BARNSLEY
Metropolitan Borough Council

REFUSAL OF PLANNING PERMISSION

APPLICATION NO. 2014/0972

**Proposal Erection of 1 no. detached dwelling.
At Land at St Austell Drive, Barugh Green, Barnsley**

NORTH ELEVATION

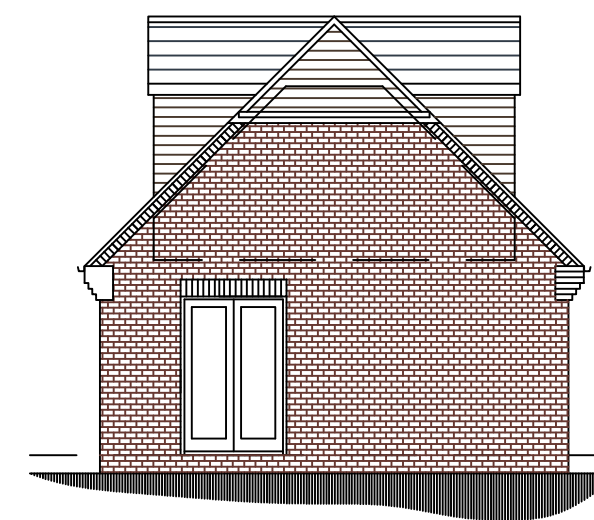
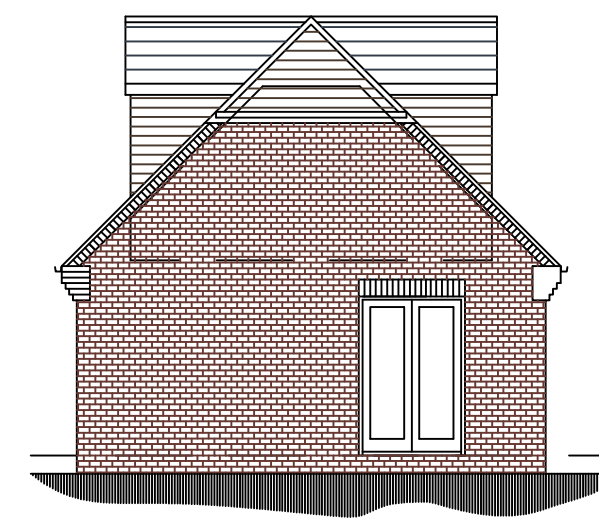
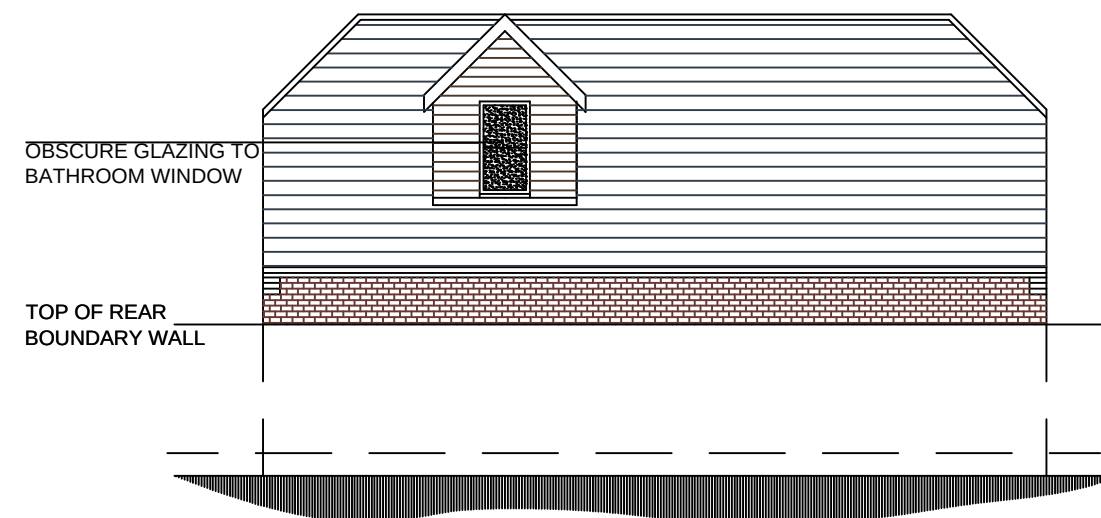
- 2 In addition the Local Planning Authority also considers that by virtue of the developments height overall mass and close proximity to the northern boundary the property would form a visually intrusive and overbearing feature when viewed from the properties to the rear of the site (nos 34-40 Barugh Green Road). It is considered that the relationship would be particularly harmful to the enjoyment of their gardens. For this reason it is considered that the proposal would not achieve a suitable relationship with adjoining land uses, this would be contrary with UDP Saved Policy H8D and Core Strategy Policy CSP29.

SITE PLAN

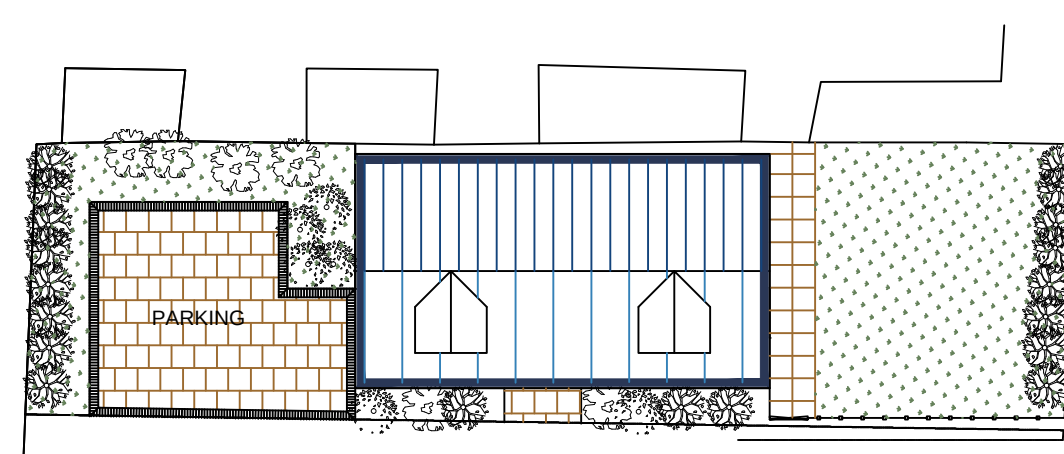
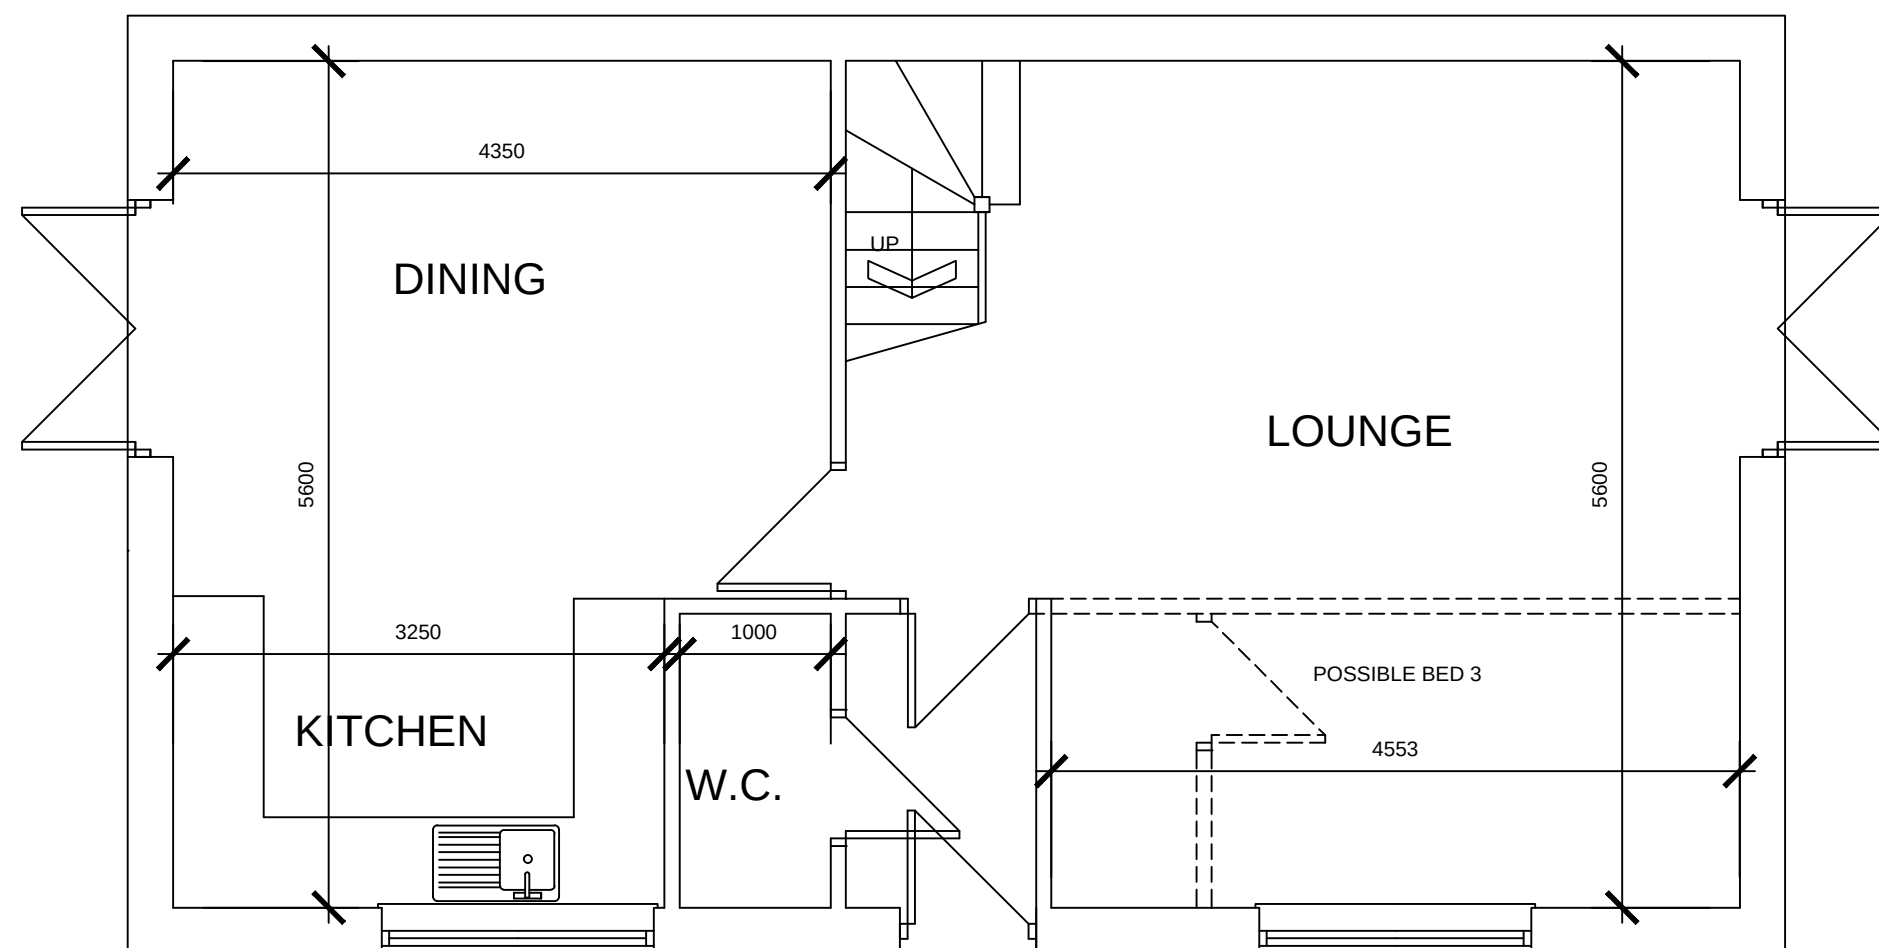
- 1 In the opinion of the Local Planning Authority the site is of an insufficient size to accommodate the proposed dwelling. It is considered that the proposal would appear as a cramped infill development which bears no resemblance to the surrounding housing stock in terms of character and scale. It is not considered appropriate to support a residential dwelling as it could not be developed in a way or context that is respectful to the established building pattern of the locality. As such it is considered that it would present itself as an incongruous and intrusive change to the established local development pattern. The proposal is therefore considered contrary to the requirements of Core Strategy policy CSP29, saved UDP policy H8D and the advice of paragraph 56 and 57 of the NPPF which promote high quality inclusive design.
